Our Ref: **R/4/13/A**
Your Ref:

Town & Country Planning (Control of Advertisement) (England) Regulations 2007 (as amended)
Application for Consent to Display an Advertisement(s)

Development 3 No non-illuminated wall mounted signage and 2 No non-illuminated signage

Location Unit A Rustington Retail Park New Road Rustington

Key Plan (NTS)

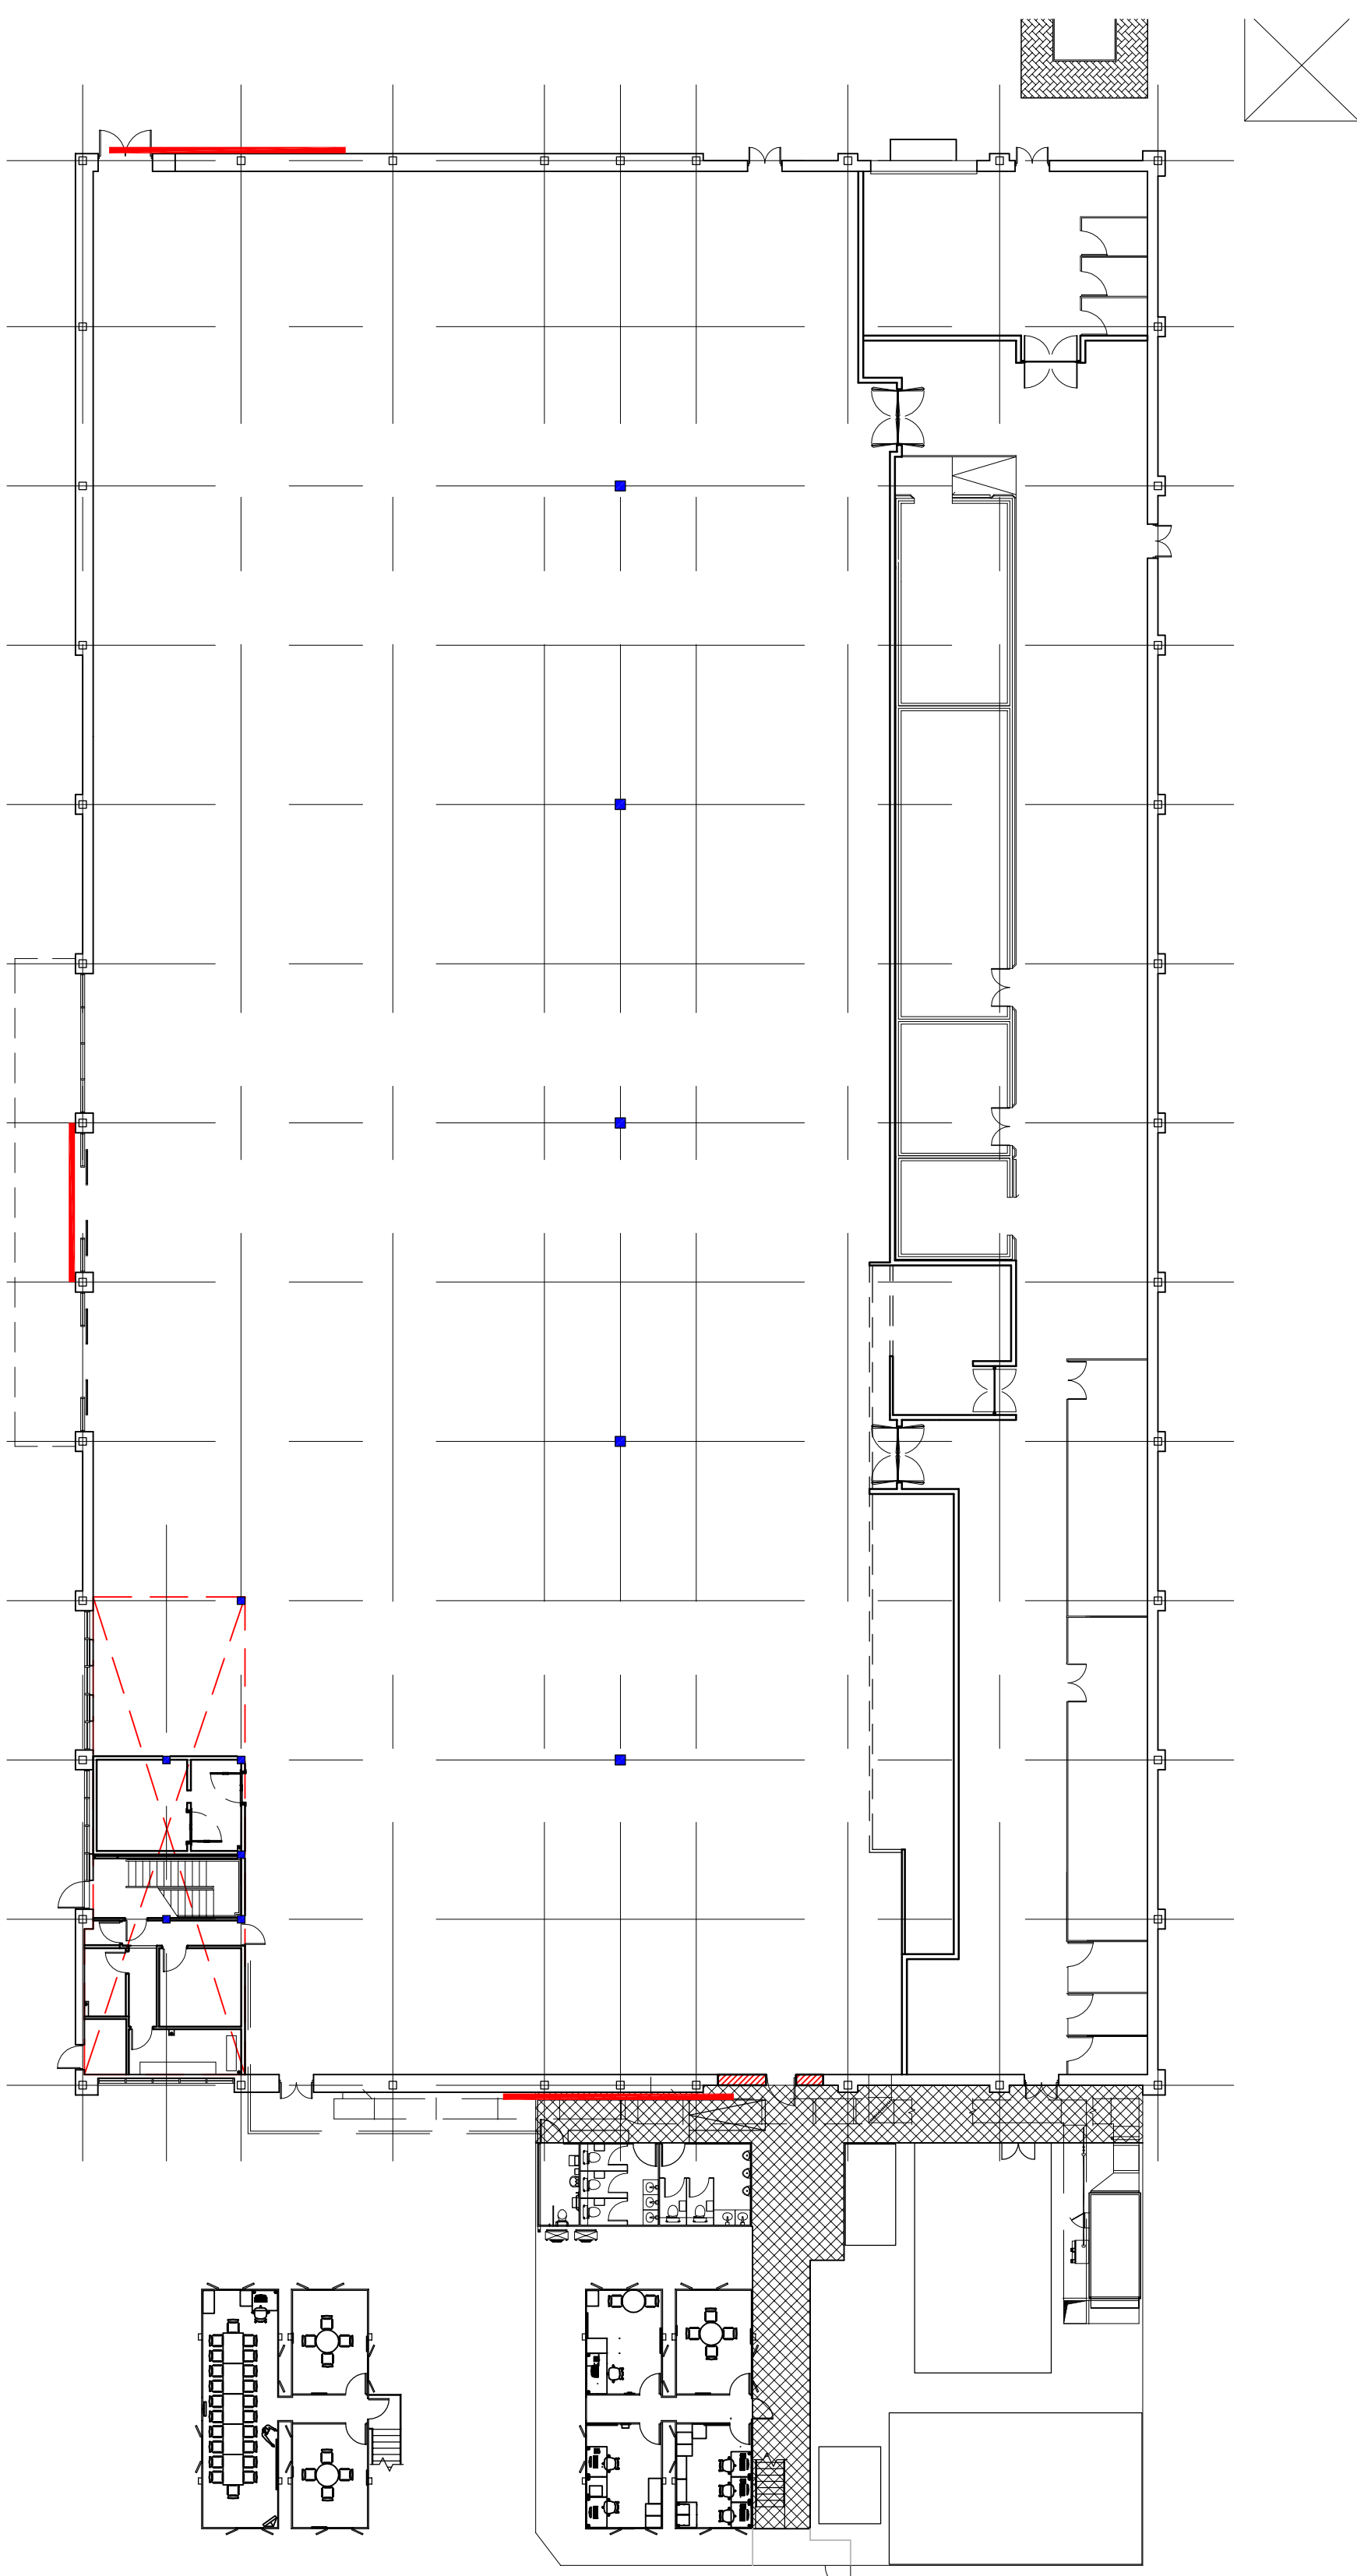
Please show the 2 No proposed Welcome signs on the floor plan on the Key Plan.

✗ Please confirm if you want to include the 2 No Totem signs in this application. If you are including these on the application, please show them on the Key Plan. *- do not include index*
